Subject: FW: AB/28/20/DOC - 20026 - 30&32a High Street, Arundel

Application ref: AB/28/20/DOC

Spencer and Freya Swaffer
30 & 32a High Street, Arundel
PROPOSED ALTERATIONS – GF

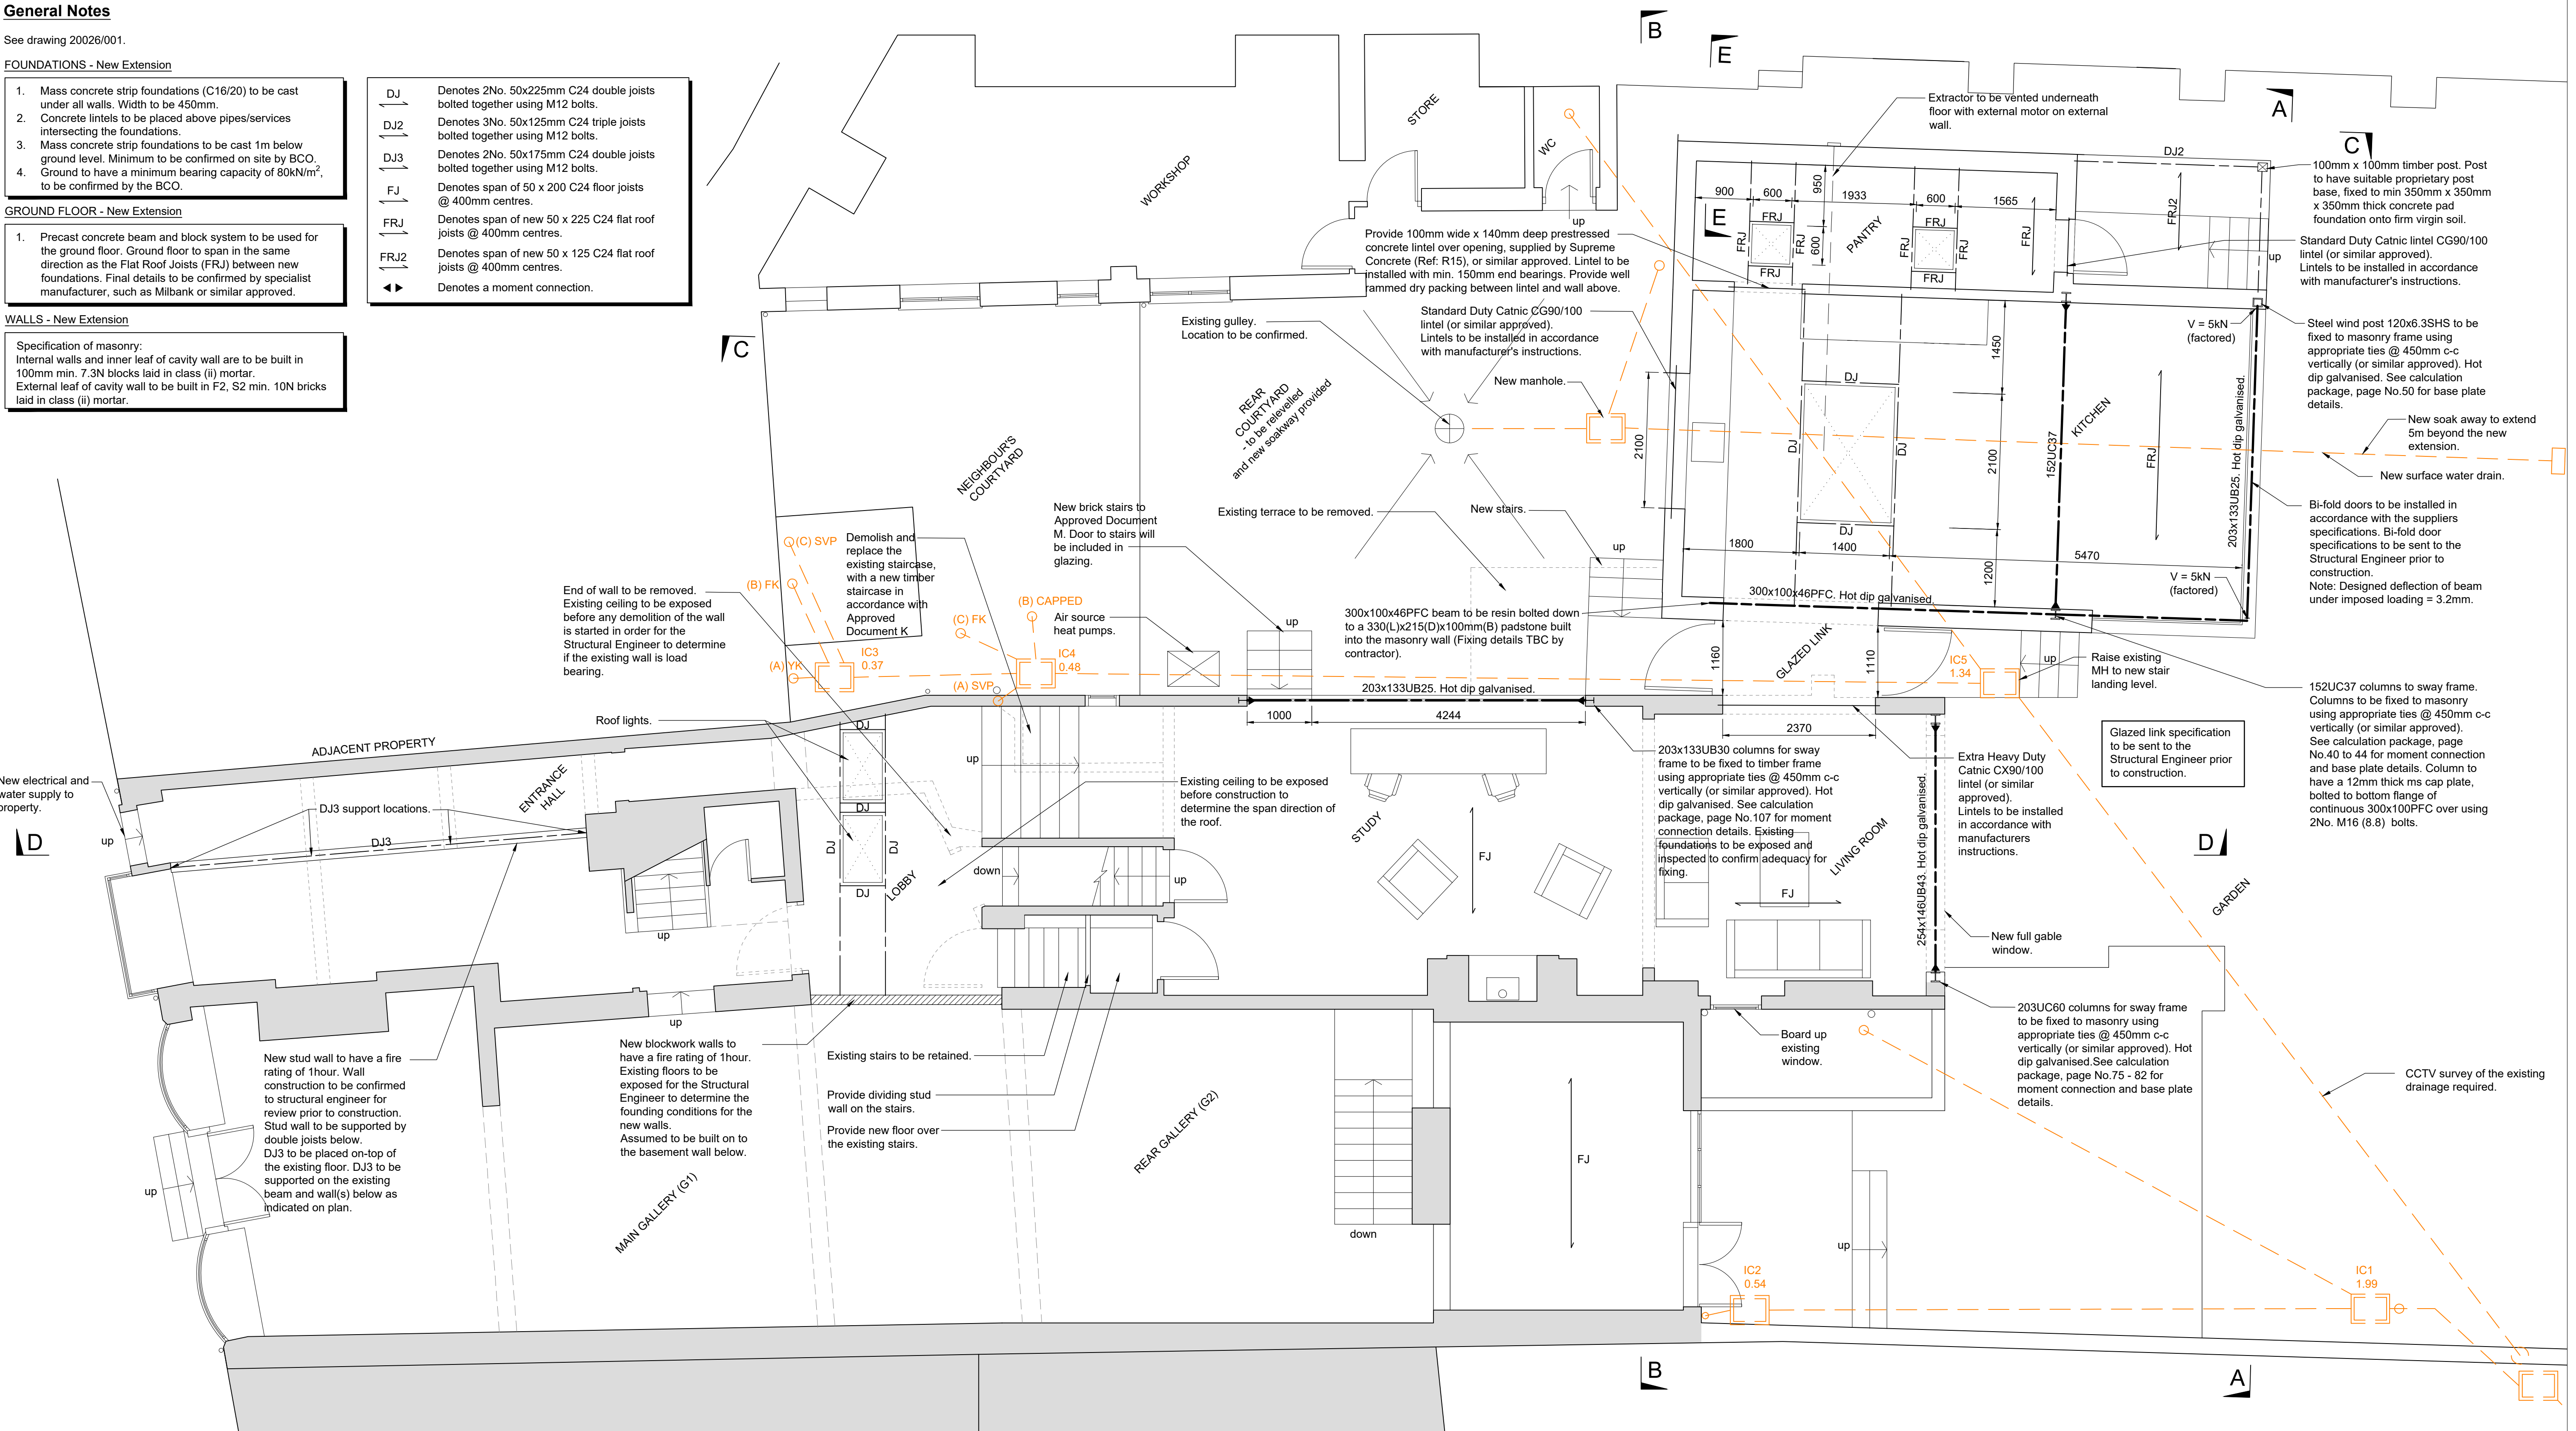
Proposed masonry - Masonry specifications on drawing, including masonry bond, have been added.

Spencer and Freya Swaffer
30 & 32a High Street, Arundel
PROPOSED ELEVATIONS

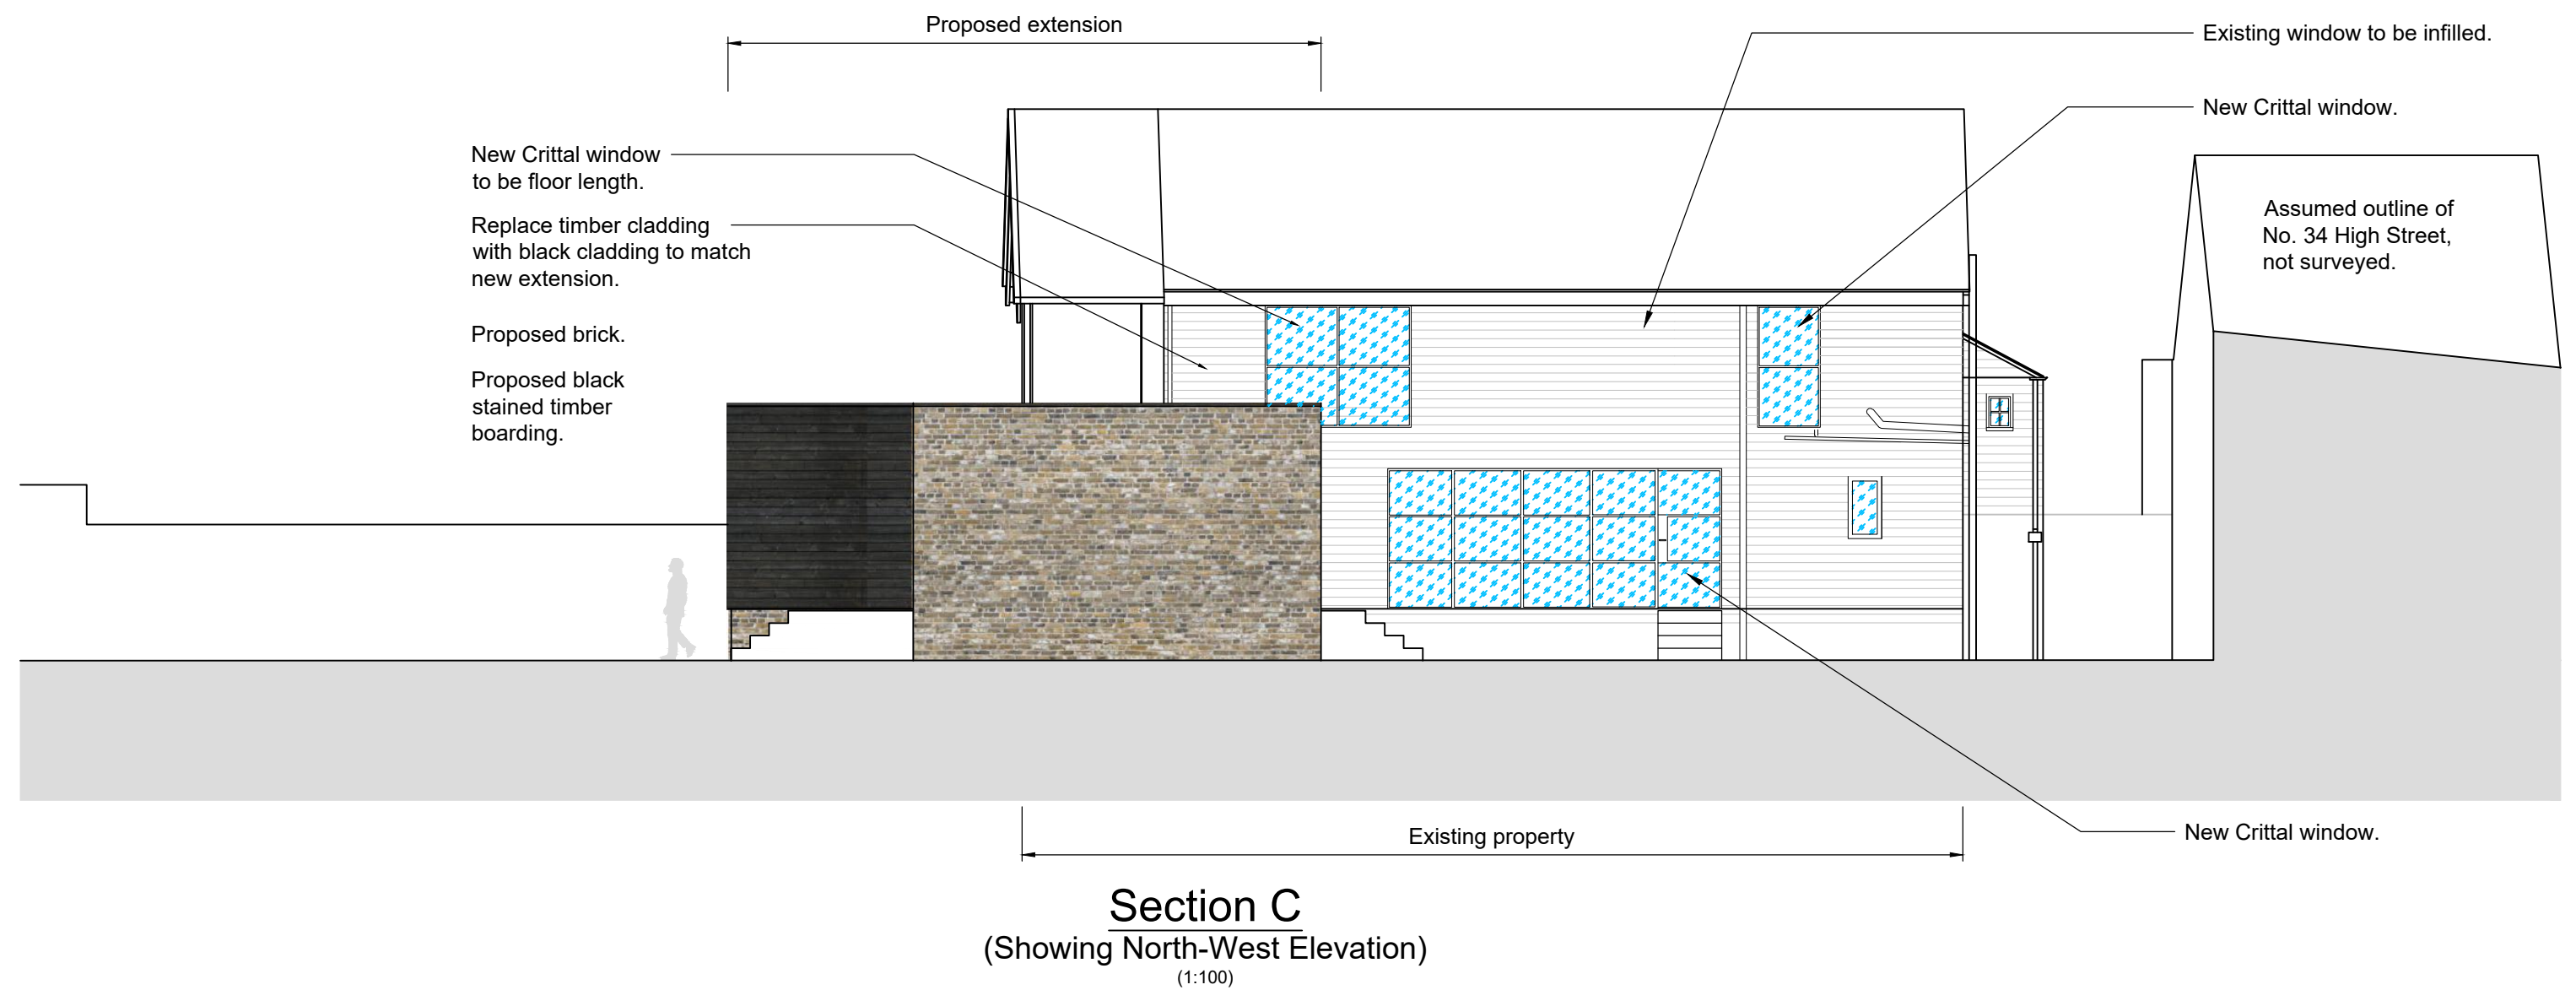
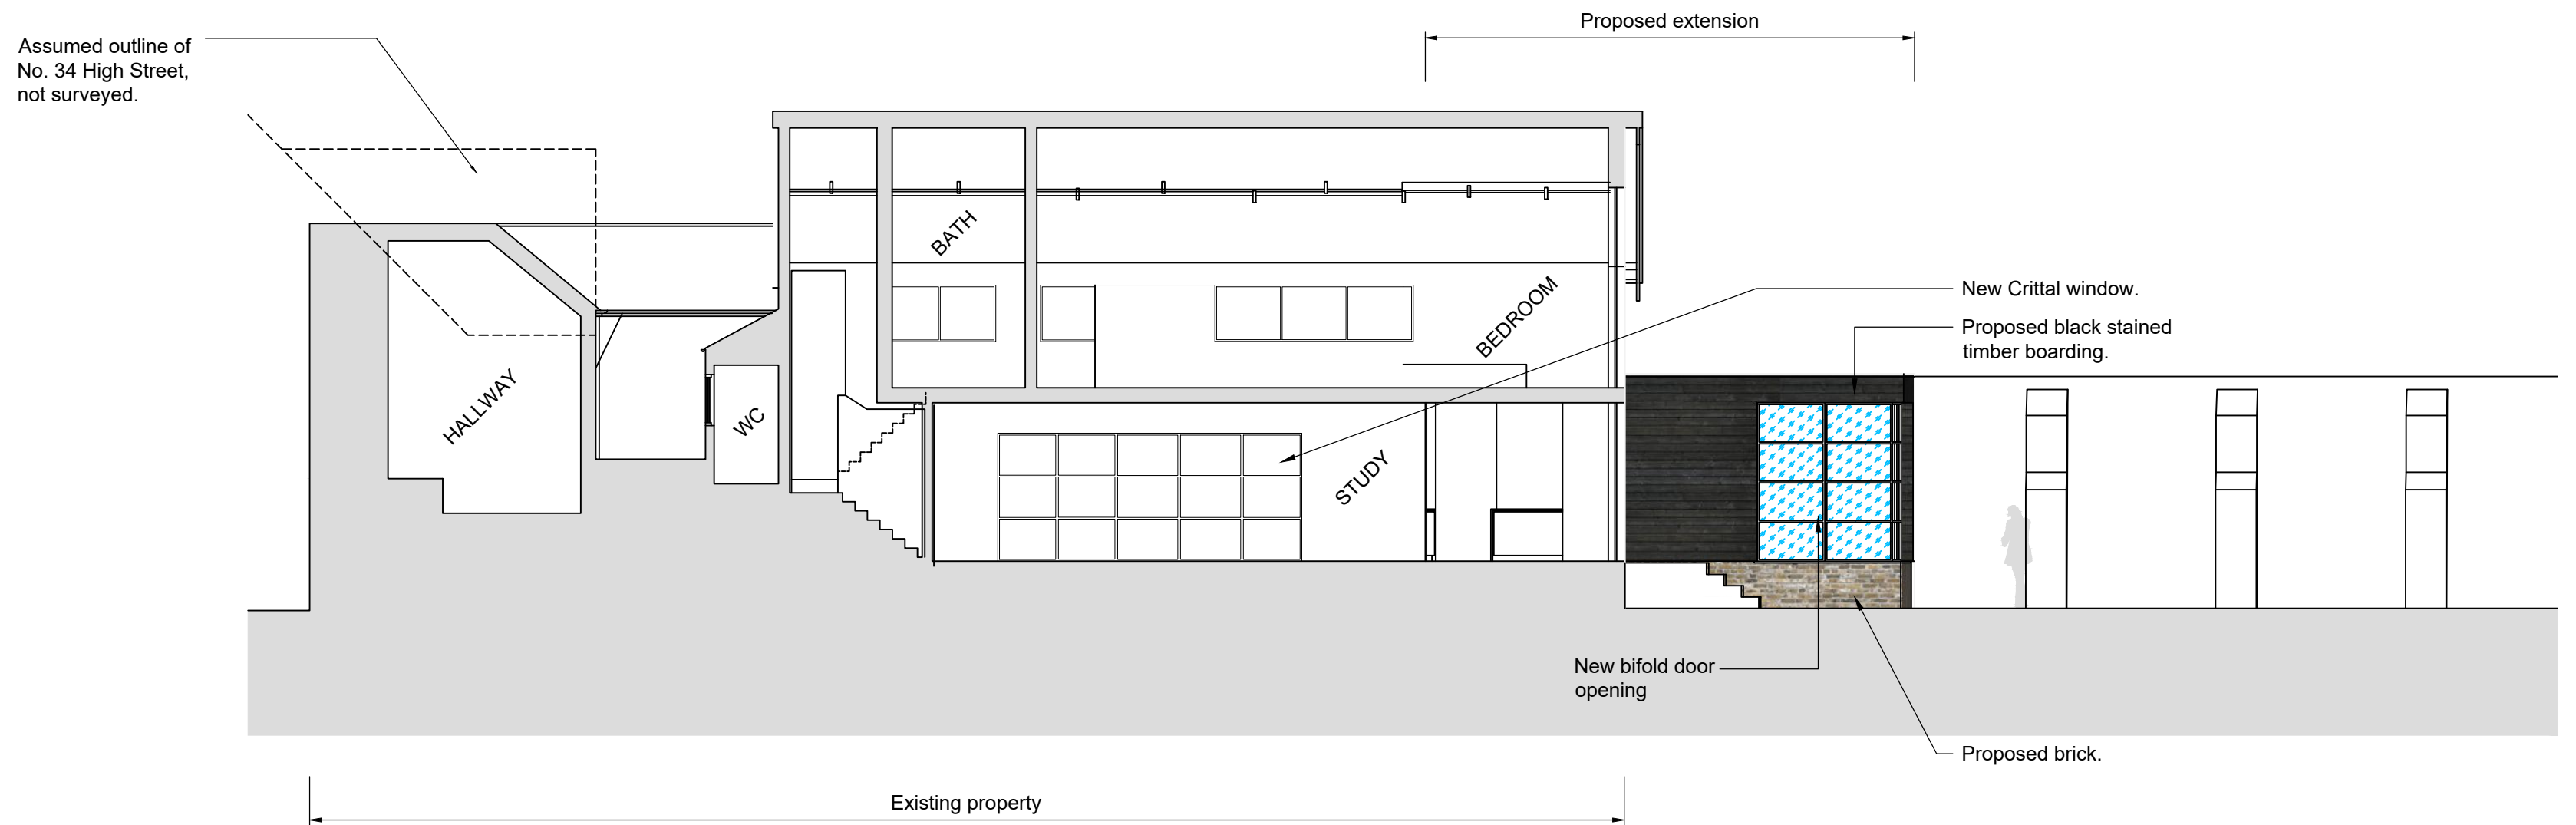
Thank you for the additional information. It was unfortunate that I was consulted so late in the process, and I had a few questions. I have reviewed the additional information and believe that it is acceptable – it is good to note that with regard to the windows that the manufacturer's specifications and notes to the elevation drawing have been added to include glazing bars. I also note reference to a sample panel being provided on site, which is acceptable.

Window glazing bars - Manufacturer's specifications and notes to the elevation drawing have been added to include glazing bars.
